Current Zoning: N1-A (Neighborhood 1-A)  
Proposed Zoning: CG (CD) (General Commercial, Conditional)

Approximately 0.97 acres located on the south side of West Mallard Creek Church Road, east of Claude Freeman Drive, and west of Stelfox Street.

The petition proposes to develop a small scale shopping center with up to 8,650 square-feet of commercial/retail space as allowed in the General Commercial Zoning District.

**SITE PLAN-1**

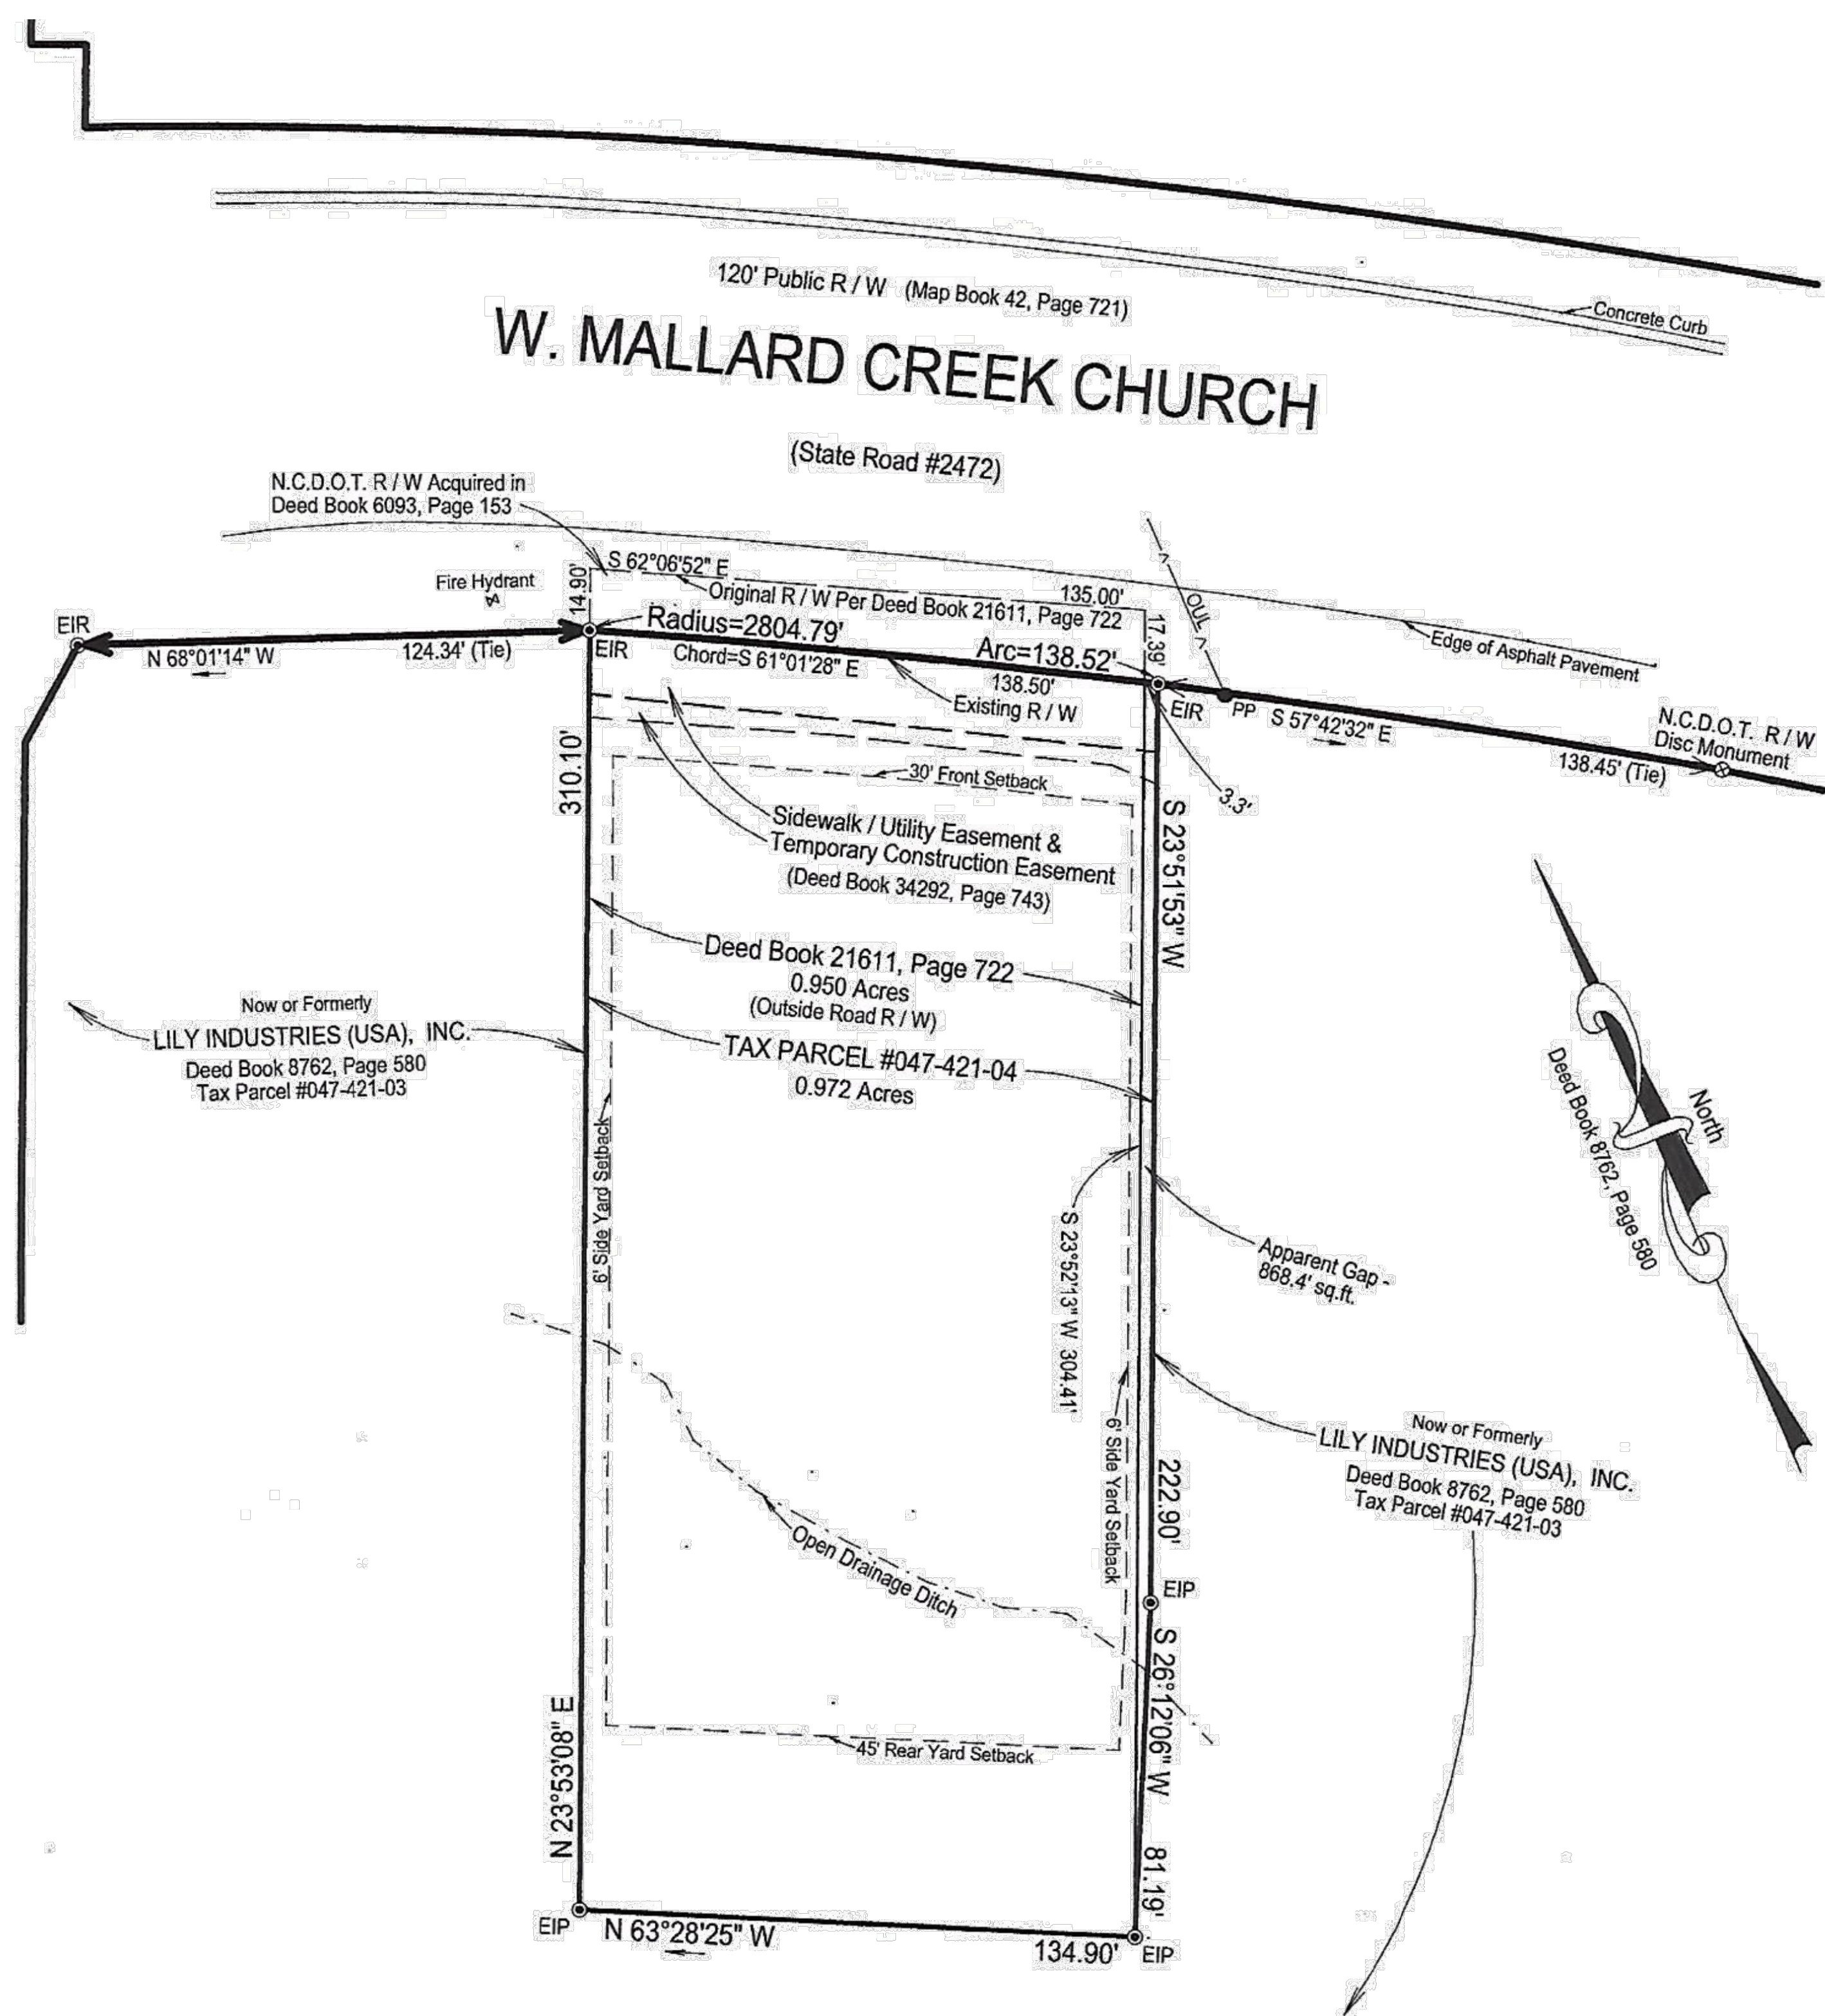
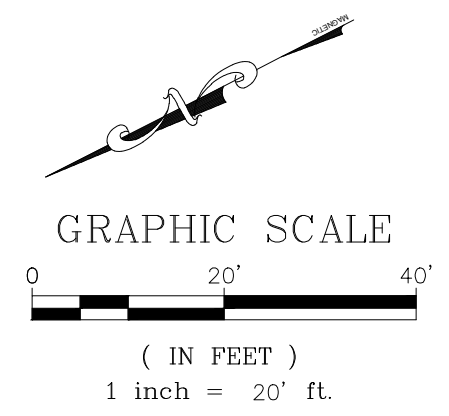
1. ~~There is a 10-foot no-build zone around tree-save area.~~ **Addressed**
2. ~~Can not have sight triangles within tree-save area.~~ **Addressed**
3. ~~Provide a tree survey.~~ **Addressed**
4. ~~Must provide a minimum of 15% tree save.~~ **Addressed**

SITE PLAN
 NEIGHBORHOOD COMMERCIAL CENTER

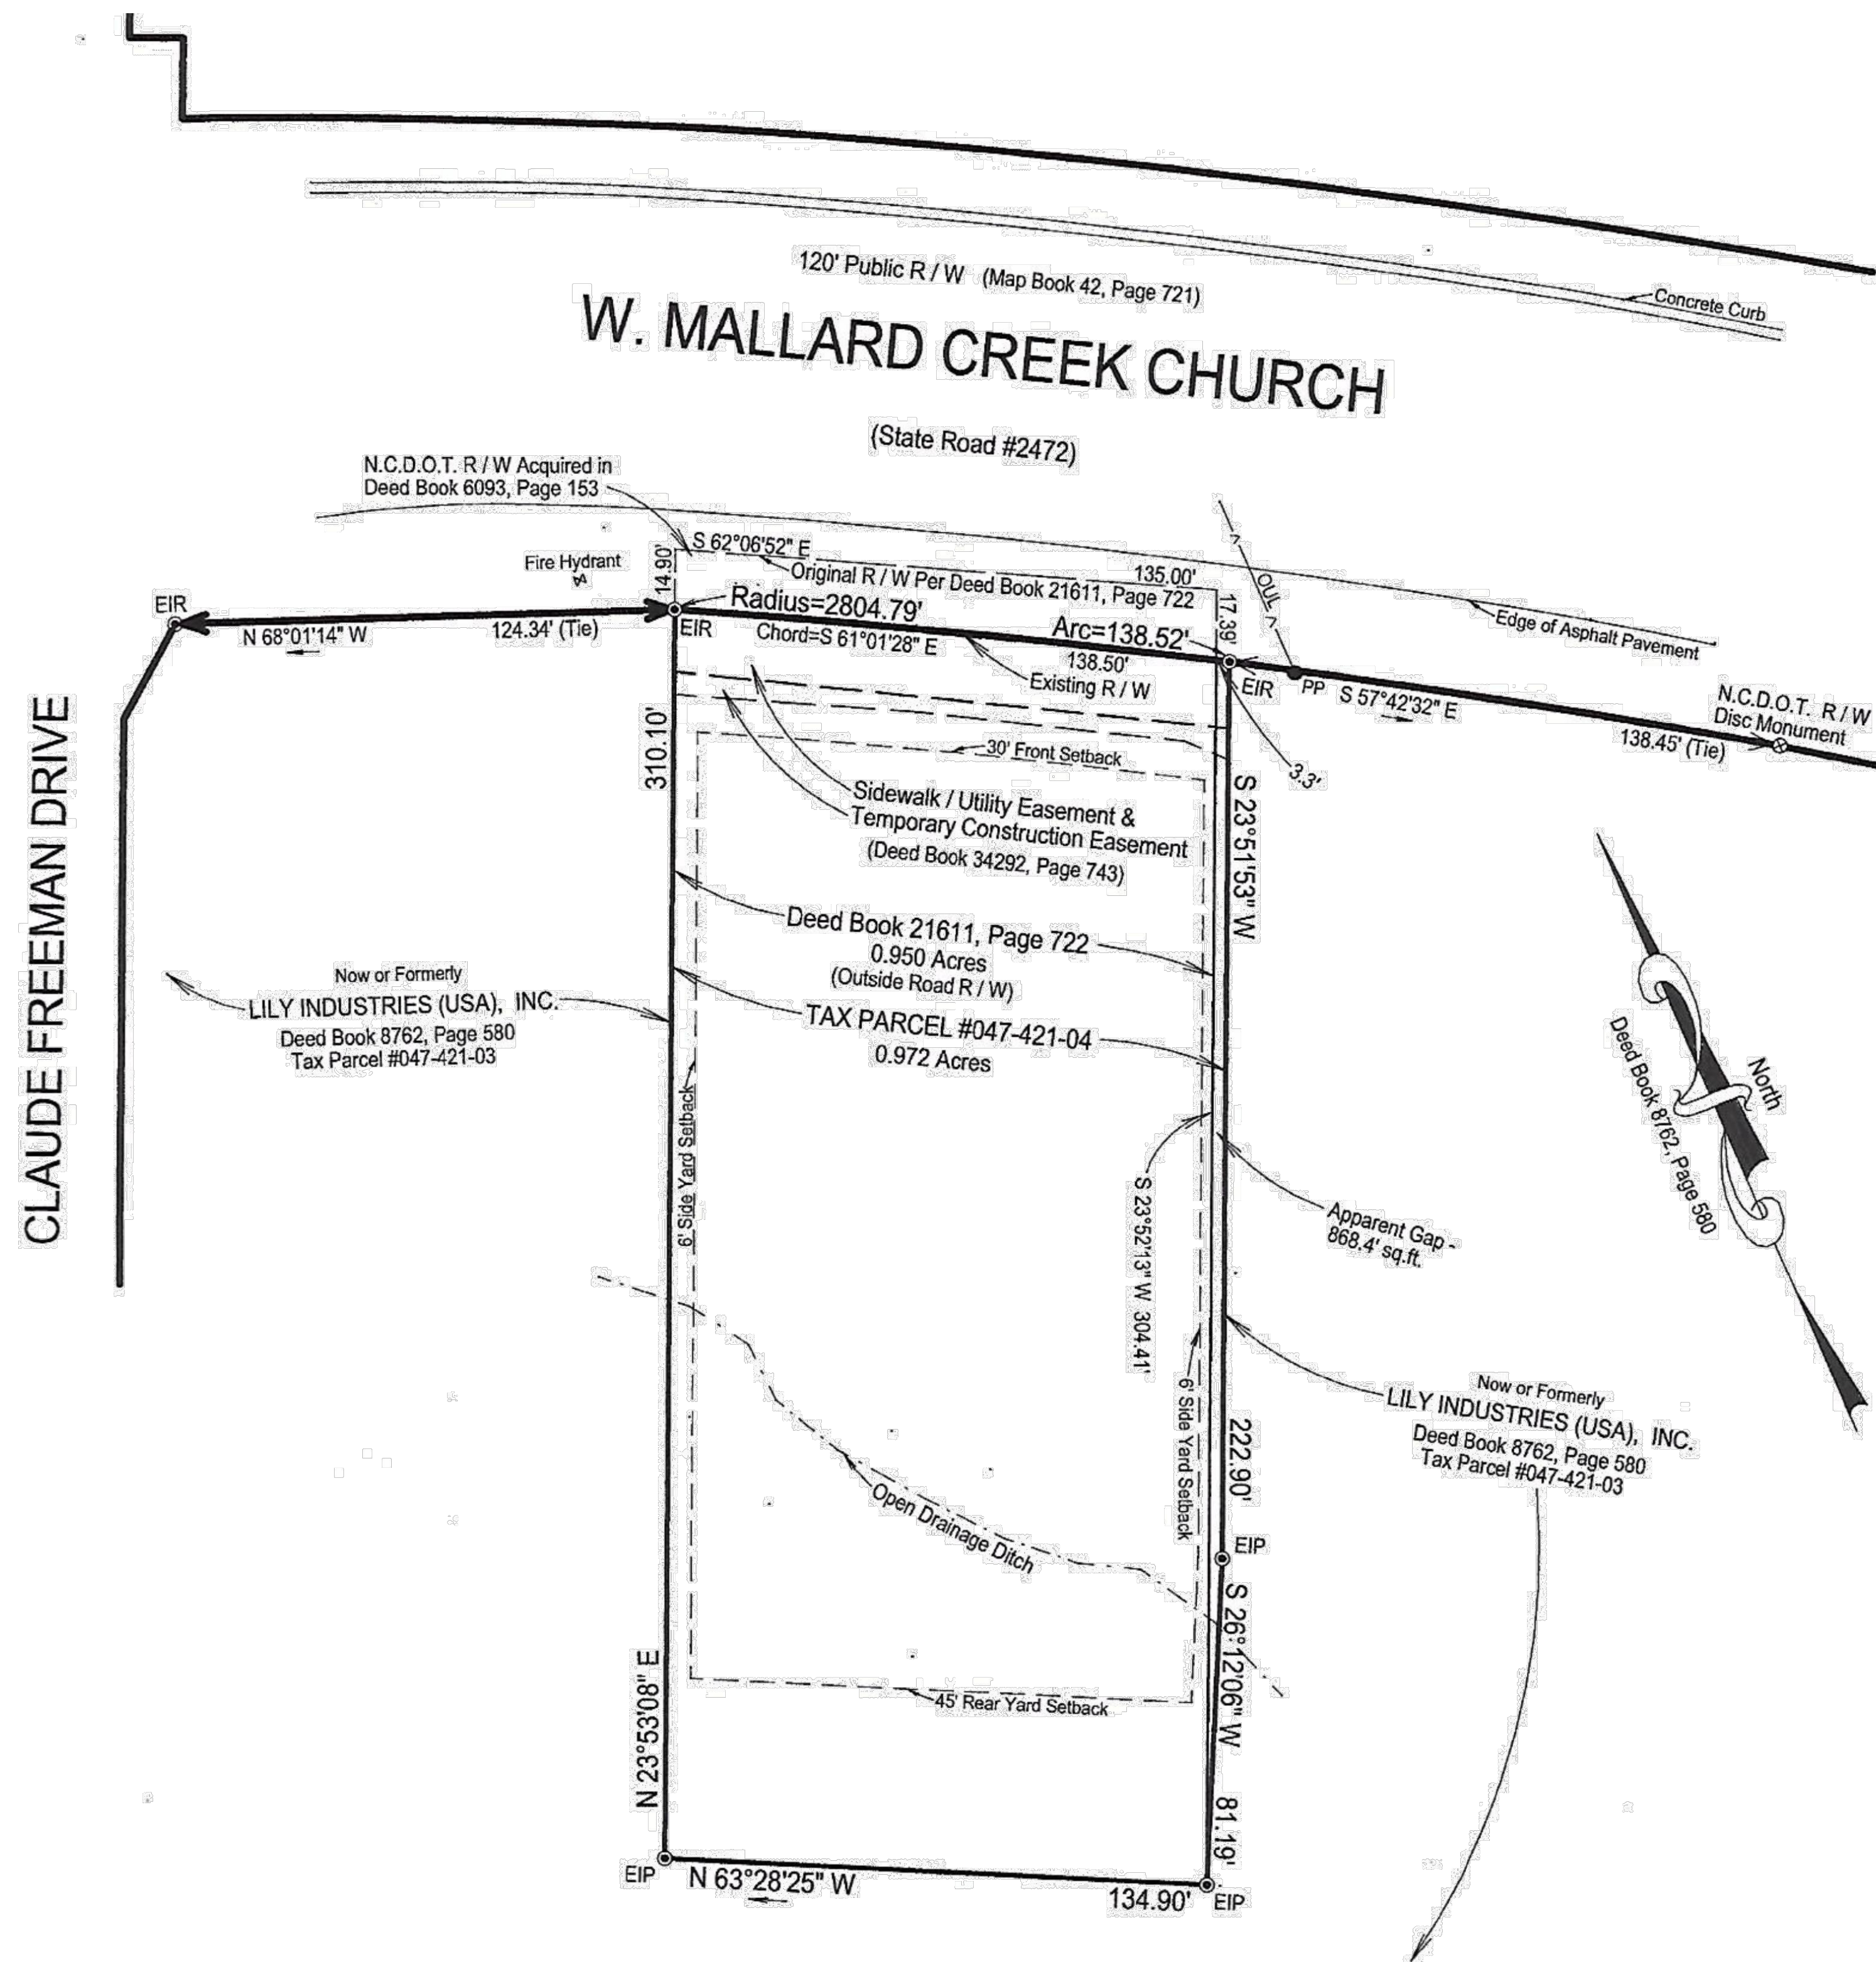
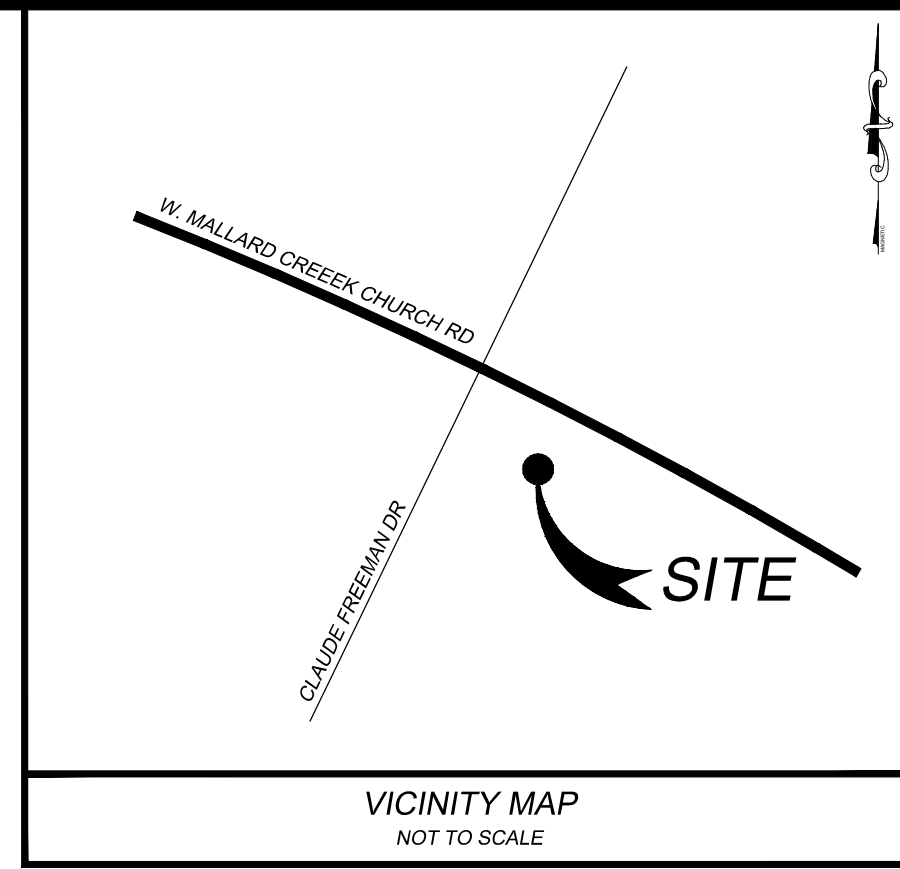
5. ~~Remove note 12 and state lighting will meet section 16.2 requirements.~~ **Addressed**
